Department of
Environment and Conservation (NSW)

Your reference :
Our reference : 282151A7:WOF13617:PW
Contact : Paul Wearne, (02) 4224 4100

**BLUESCOPE STEEL COGENERATION PLANT
PROPOSED SALT WATER COOLING**

DEC COMMENTS ON REPORTS SUBMITTED TO DATE

Note: Figure Shows One Instant in Time (2004/02/25 00:00)

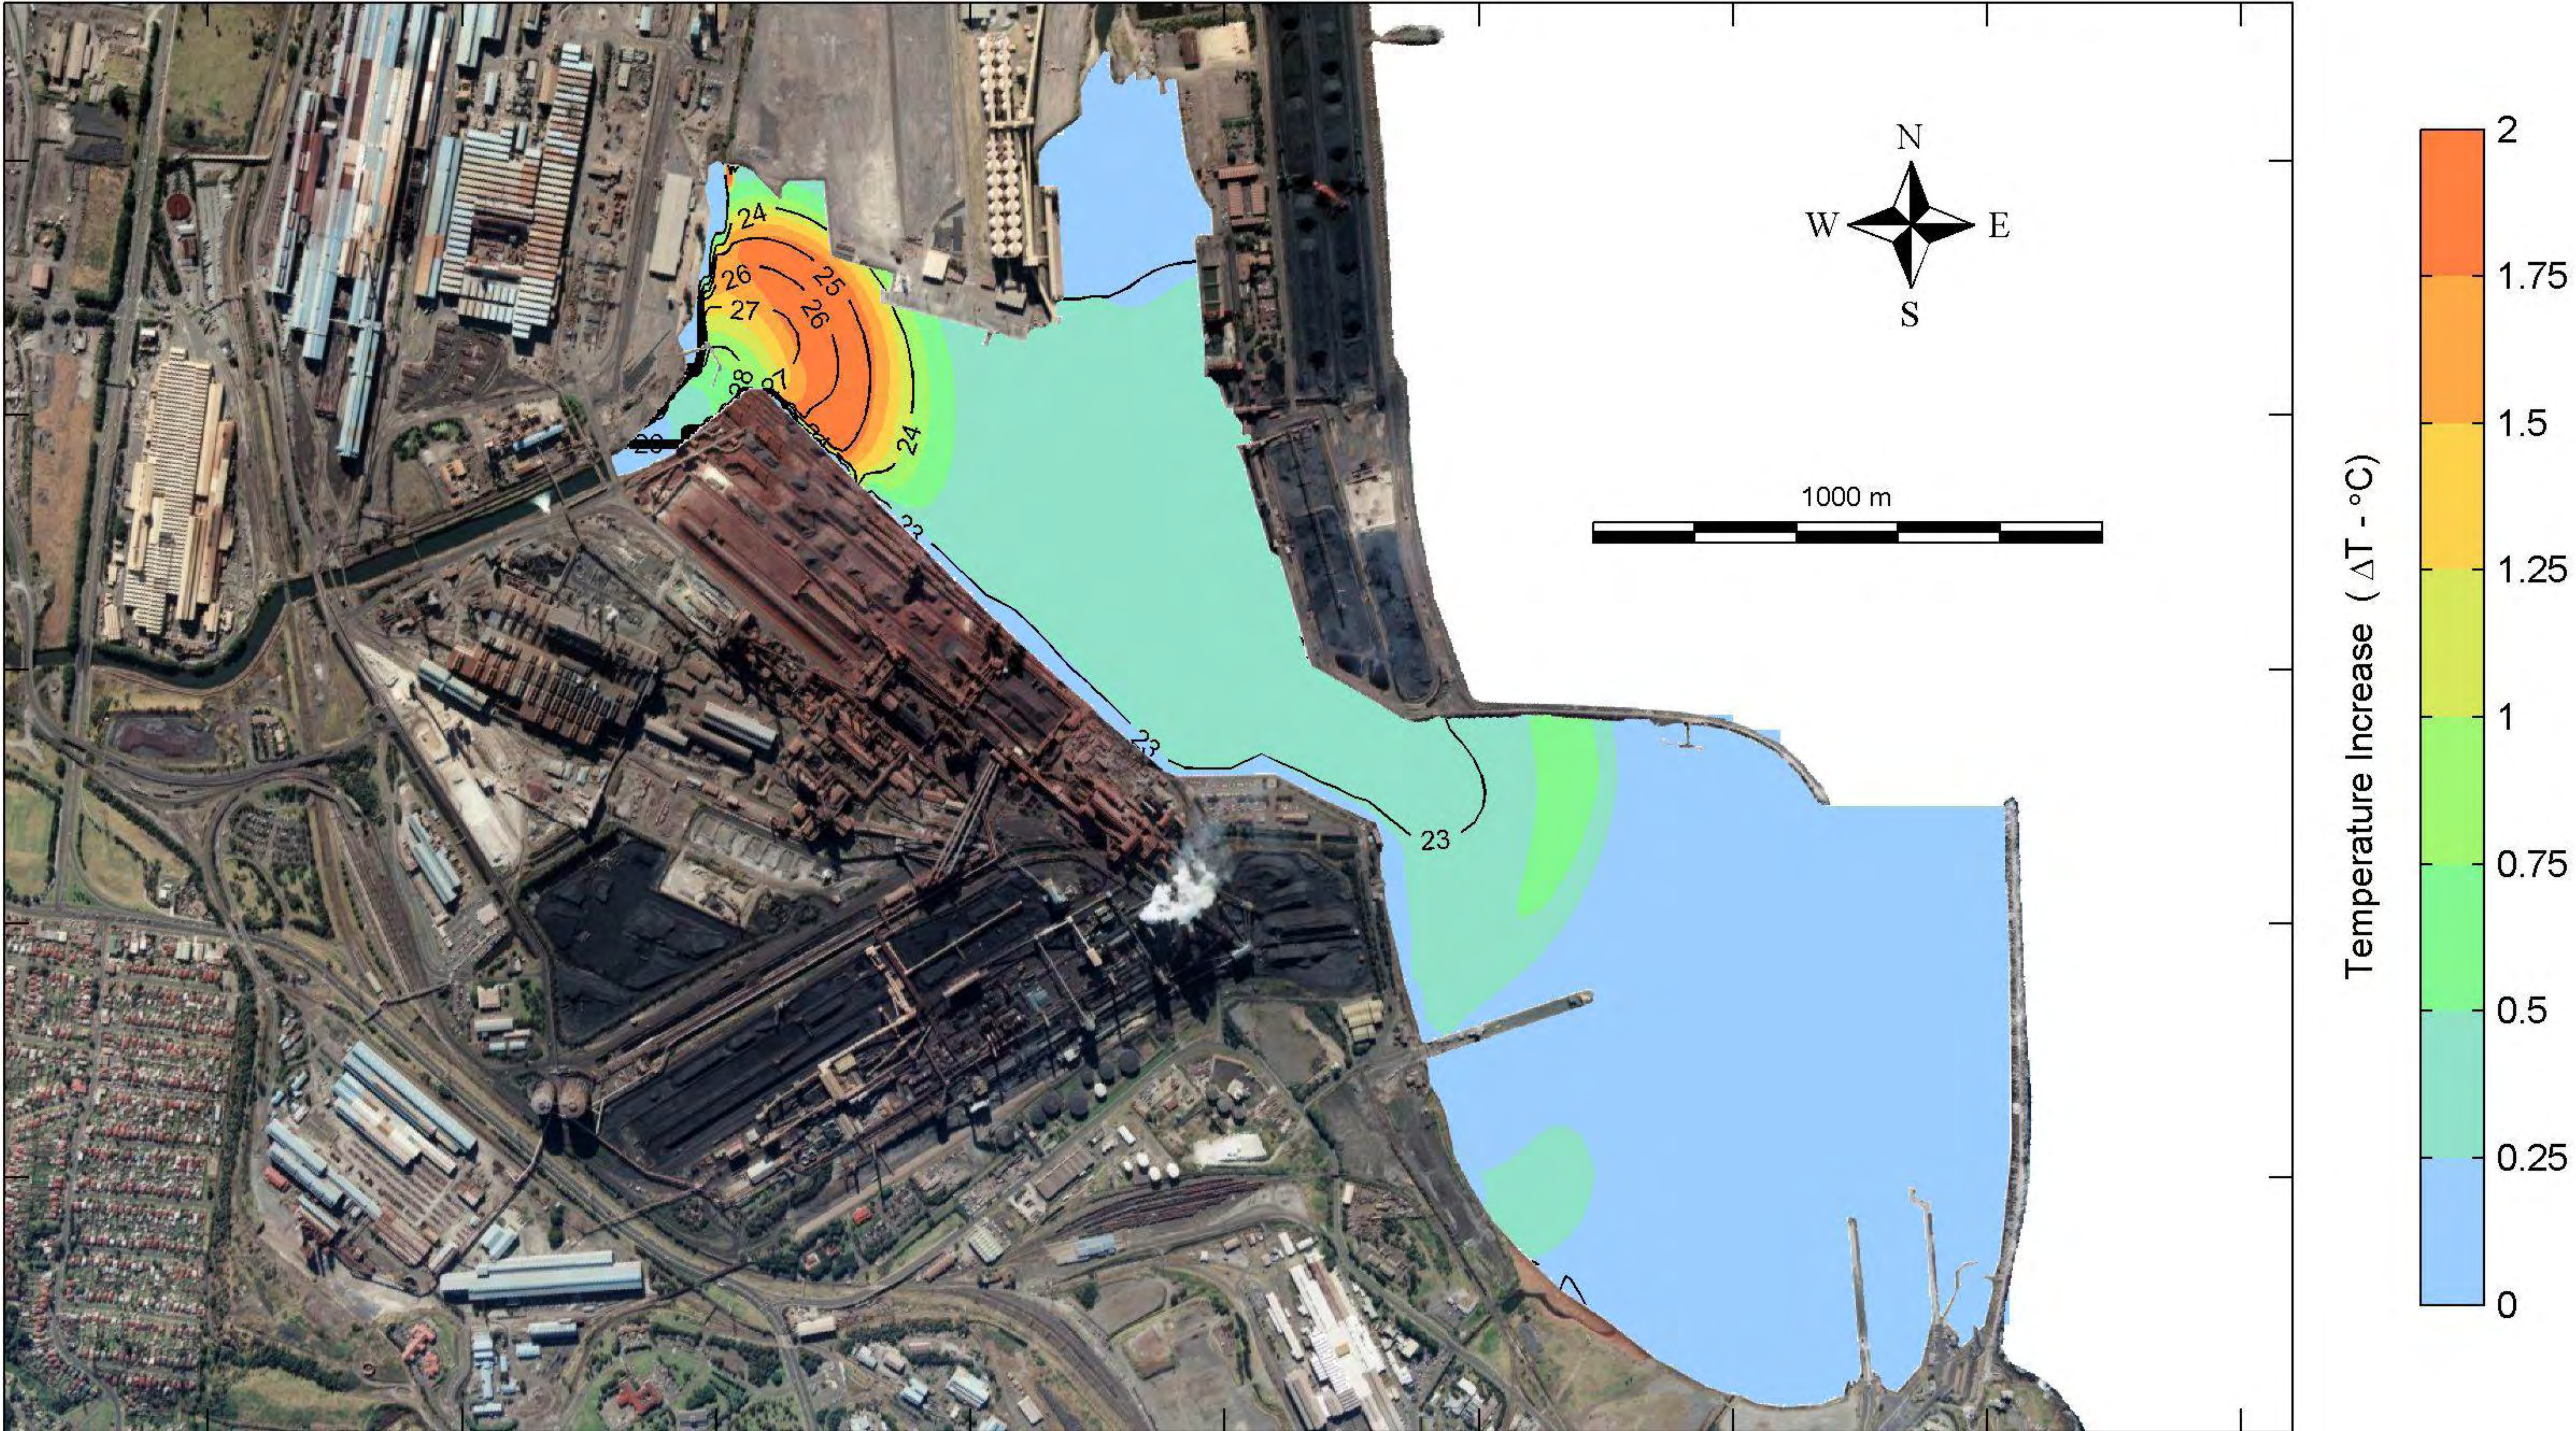
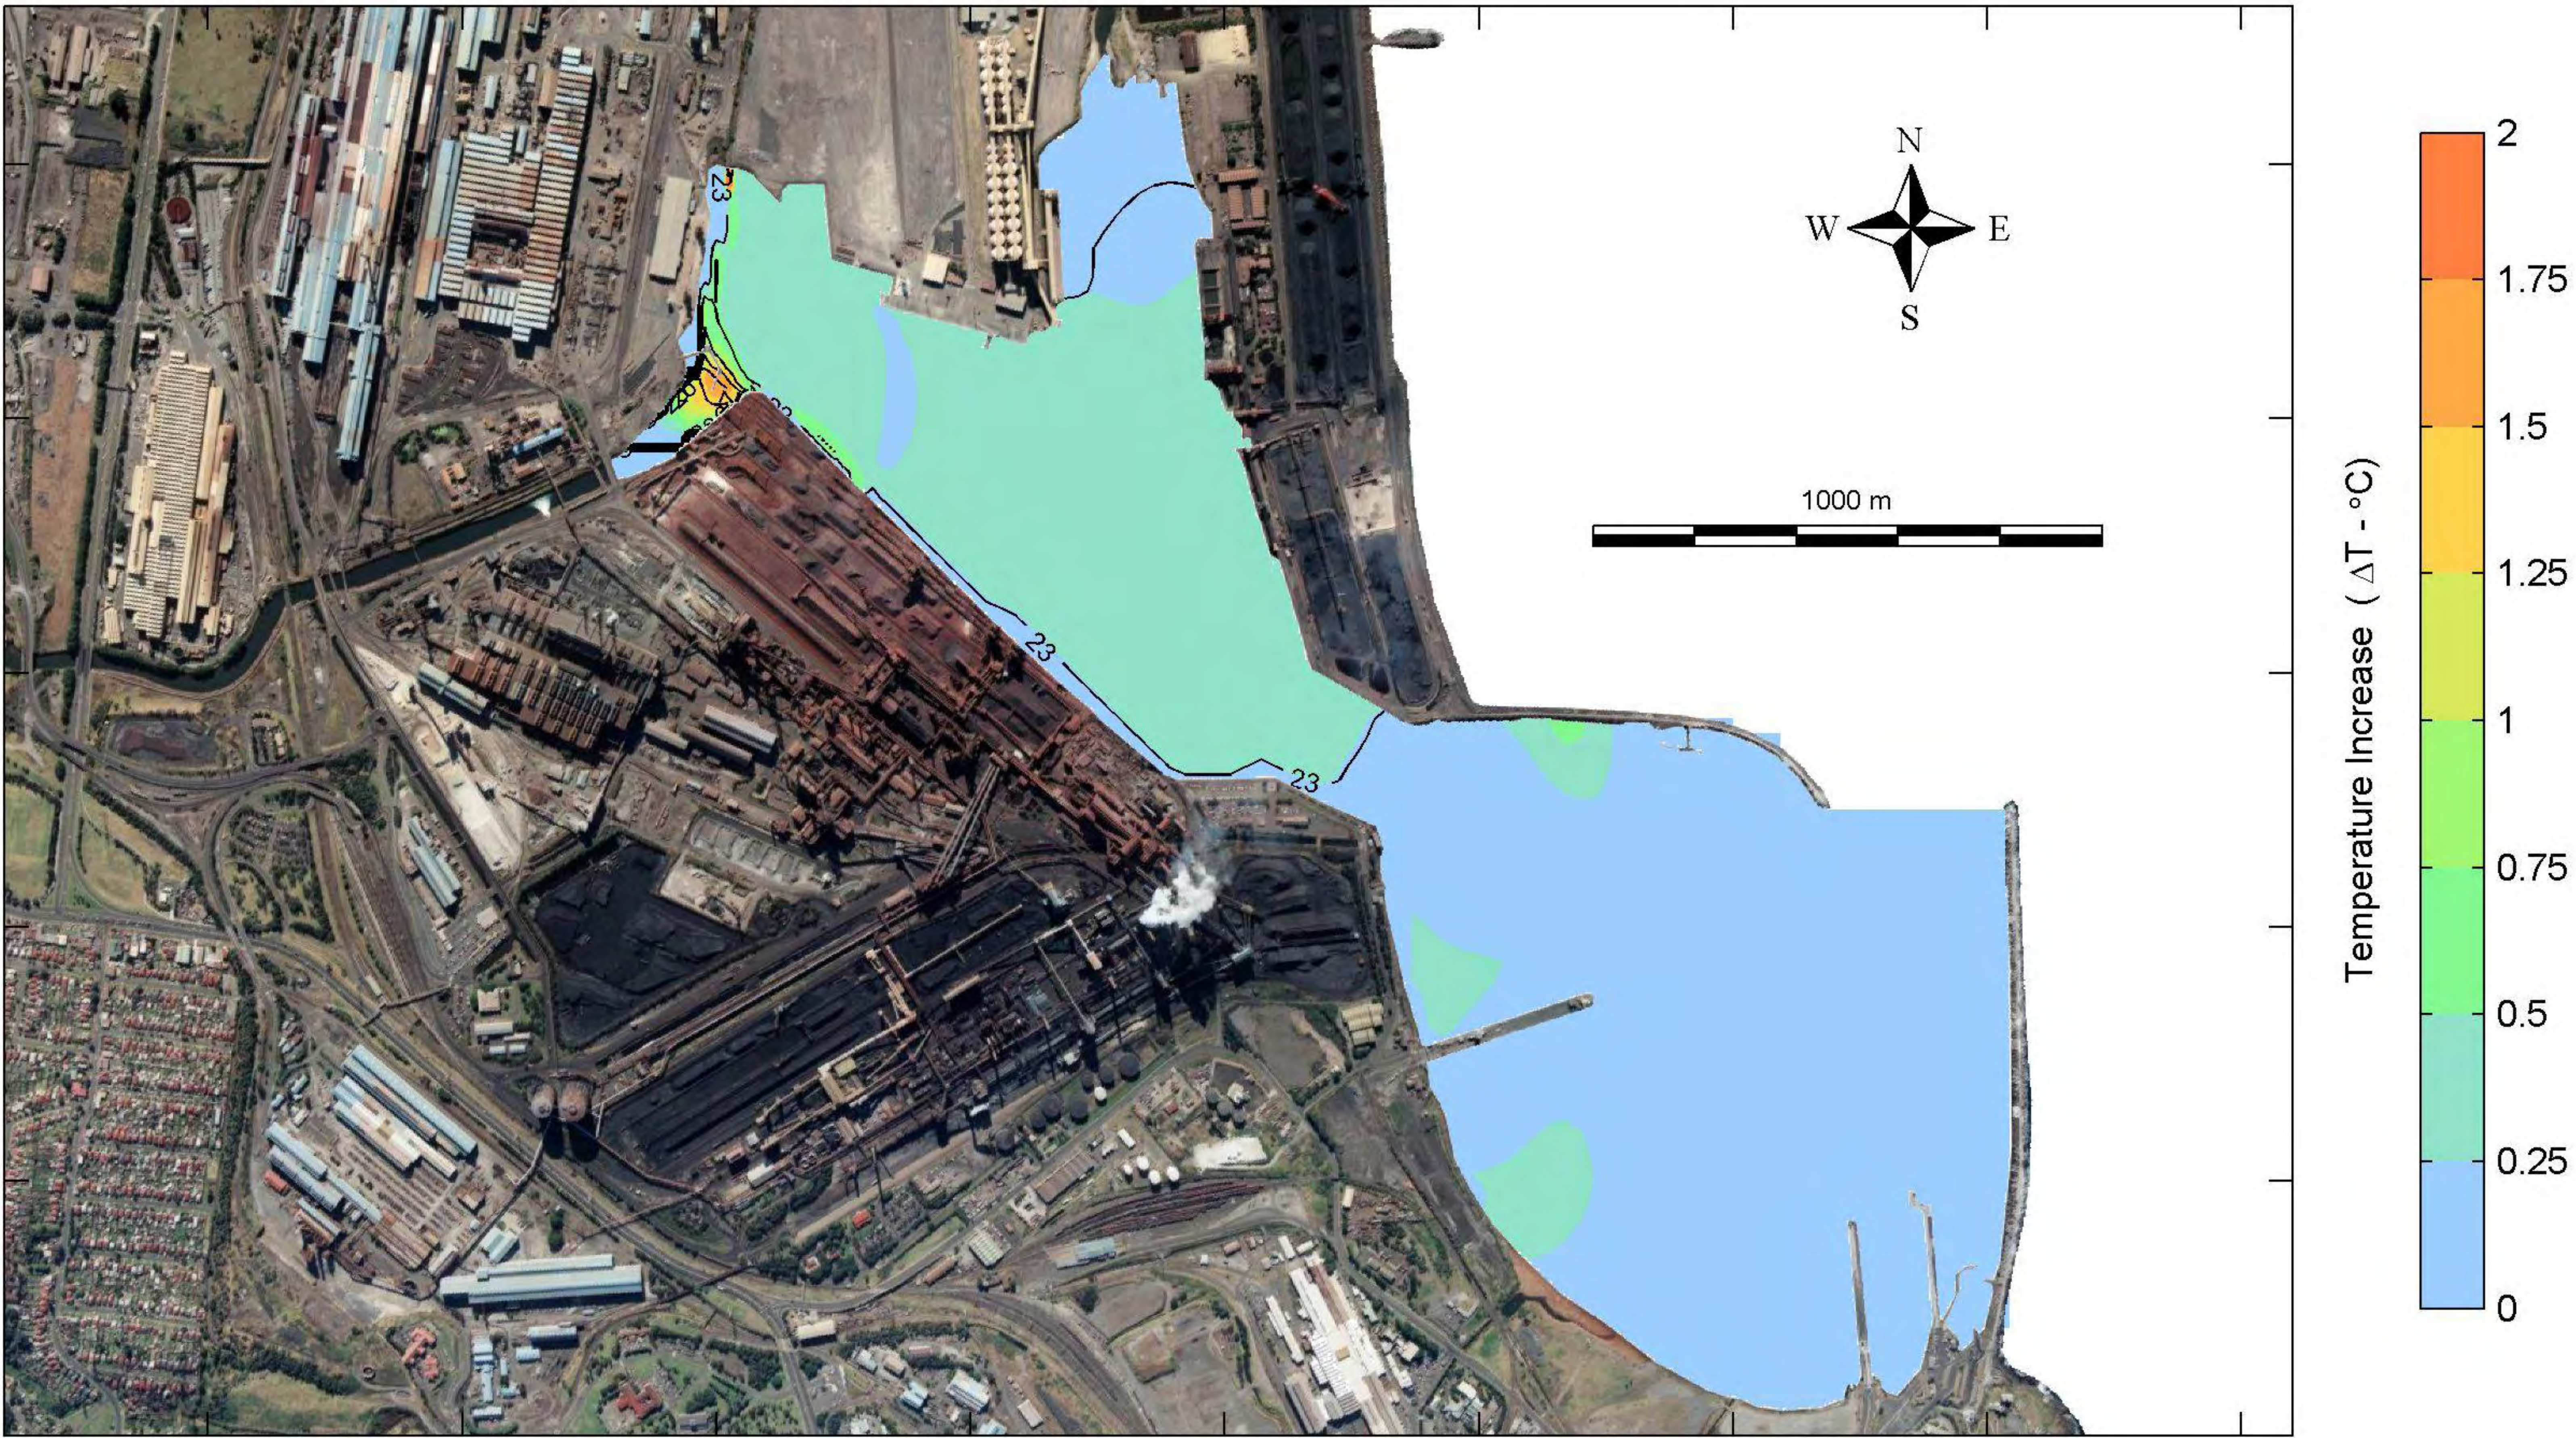
Model scenarios should describe a set of worst case conditions (from an environmental perspective) as well as typical conditions. Modelling investigations must, therefore, include simulation of average daily and maximum heat loads for all seasons including winter when temperature increases may be greatest due to cooler receiving waters (existing modelling focused on the period from 1st Jan to 28th Feb when the heat load is expected to be greatest).

Results of modelling scenarios should also be presented as differences between water temperatures with and without the thermal loading in order to illustrate the extent of the thermal disturbance above ANZECC (2000) trigger criteria. That is, the simulated 50th percentile temperatures must be compared with 80th percentile natural ambient temperatures. This analysis can be undertaken for a summer period (e.g. 1st Jan to 28th Feb) and an equivalent winter period when ambient water temperatures are at a minimum.

The adoption of 22.5°C as the boundary temperature condition must be substantiated.

It will be necessary to verify the model against observation of actual water temperatures across the modelling domain. Any existing verification data for the current discharge should be presented to validate the model which will be used for assessment of proposed discharges.
